An
Coimisiún
Pleanála

Commission Order
ABP-321734-25

Planning Authority Reference Number: ED24/141

WHEREAS a question has arisen as to whether renovation of an existing dwelling, the demolition of 37 square metres of domestic extensions to the rear of dwelling, demolition of water tank and shed (combined 10.48 square metres) to the side of dwelling, and construction of 40.3 square metres extension to the rear at Kileenavara, Kinvara, County Galway, is or is not development and is or is not exempted development:

1
-
GROUND FLOOR PLAN - PROPOSED
1:100

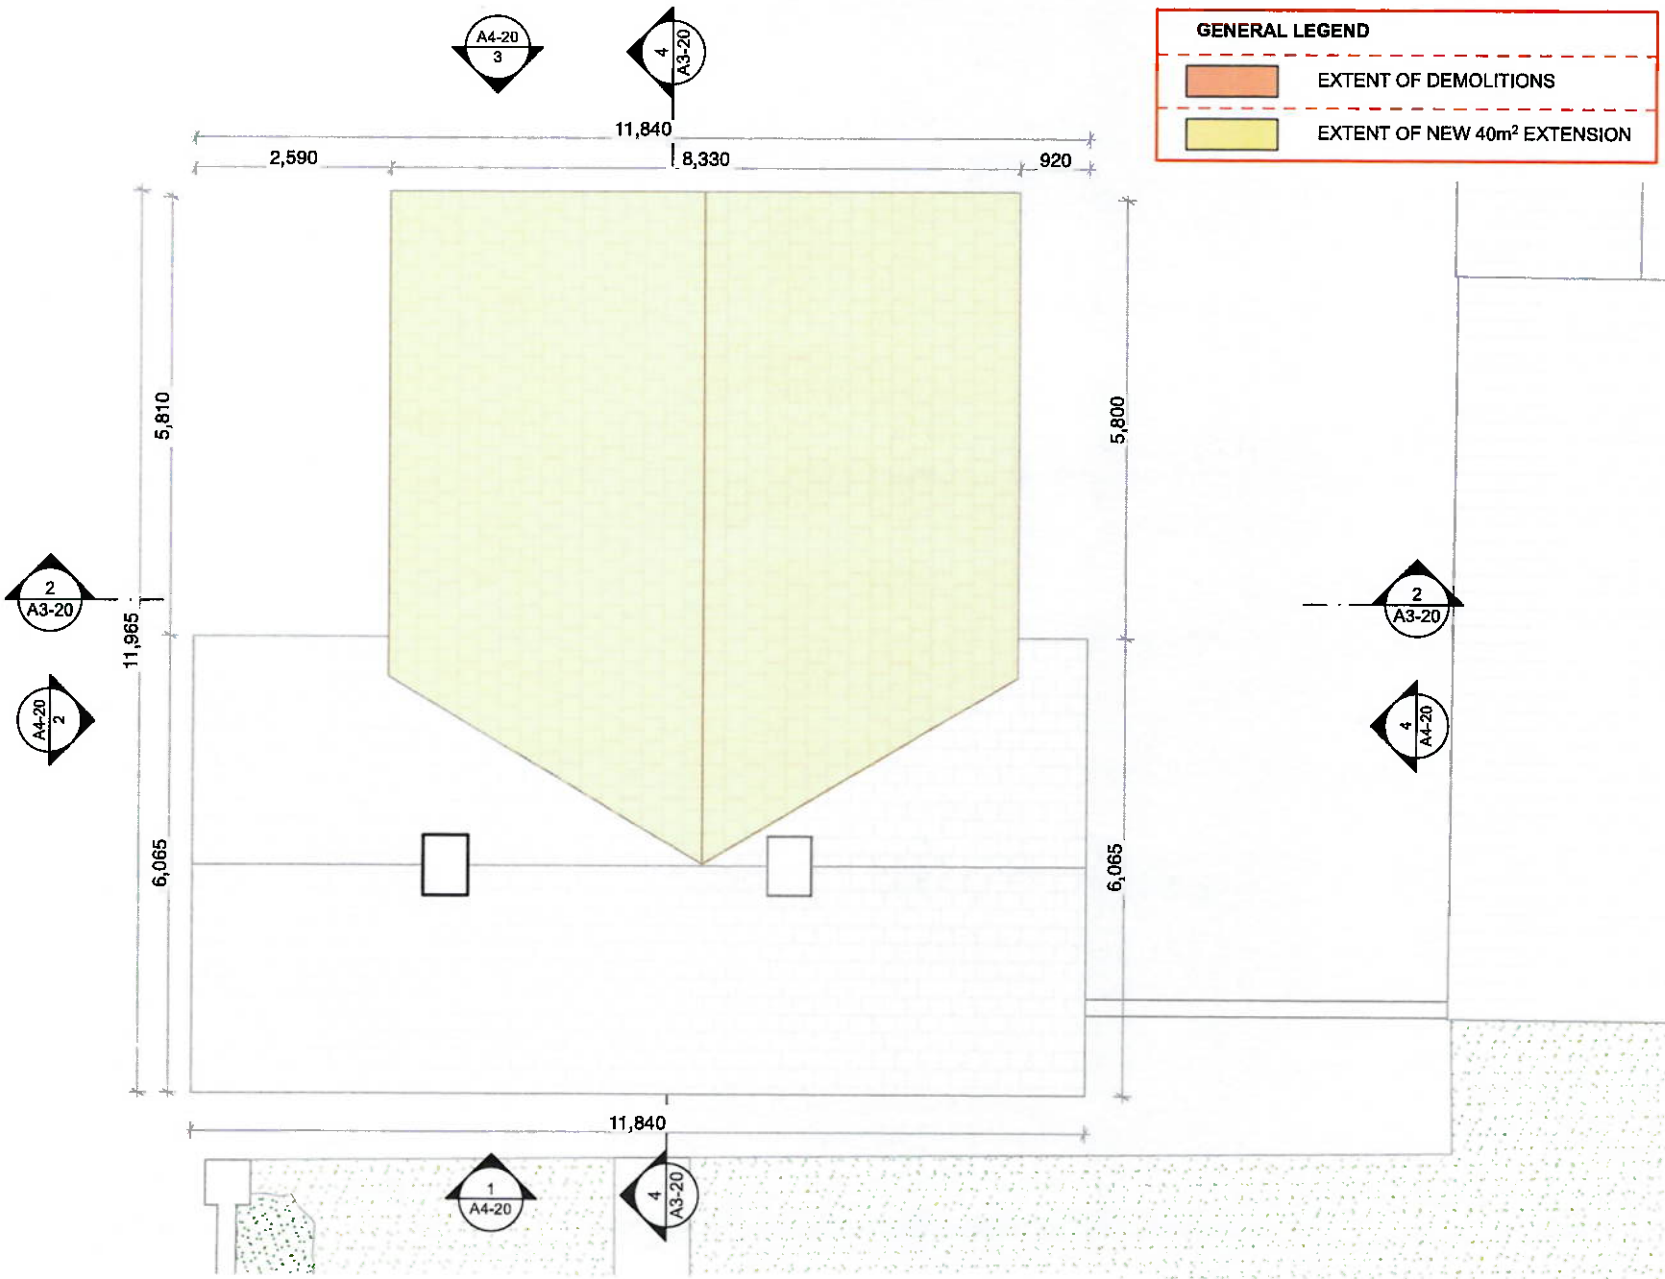
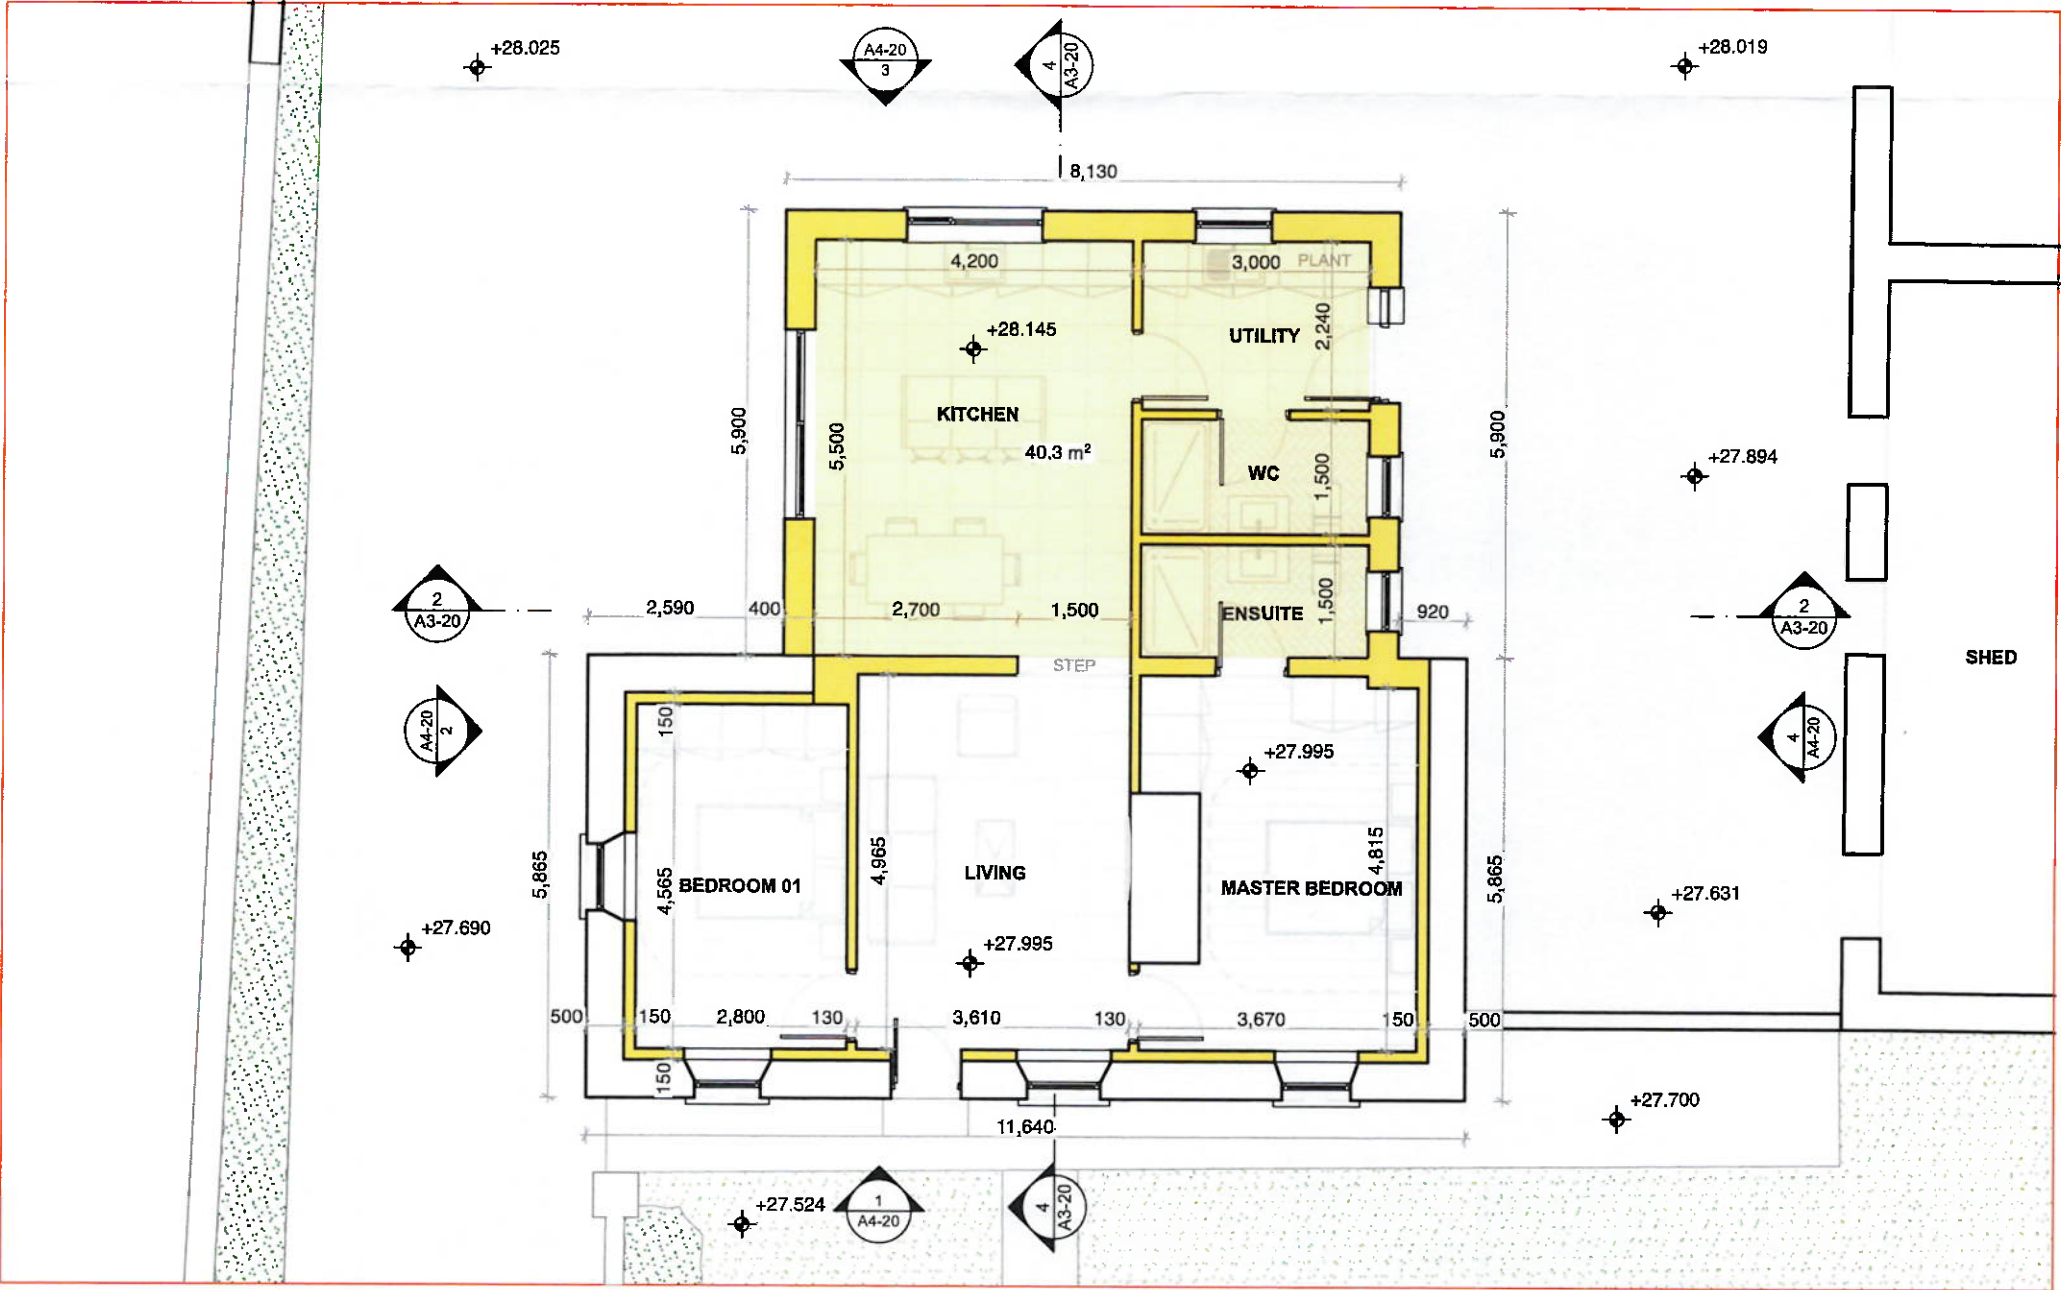
- (f) the proposed extension comes within the scope of Class 1 of Part 1 of Schedule 2 to the Planning and Development Regulations 2001 but does not meet the conditions and limits set out in Column 2 as it would exceed 40 square metres floorspace (specifically, it would not meet Condition and Limitation number 1(a) of said Class as the floor area exceeds the limit by 0.3 square metres);

- (g) demolition of the existing domestic extensions does not come within the scope of Class 50(b) of Part 1 of Schedule 2 to the Planning and Development Regulations 2001 as it would not be connected to provision of an extension in accordance with Class 1 of Part 1 of Schedule 2 to the Planning and Development Regulations 2001 (as Condition and Limitation number 1(a) of Class 1 is not met as indicated above at (f));
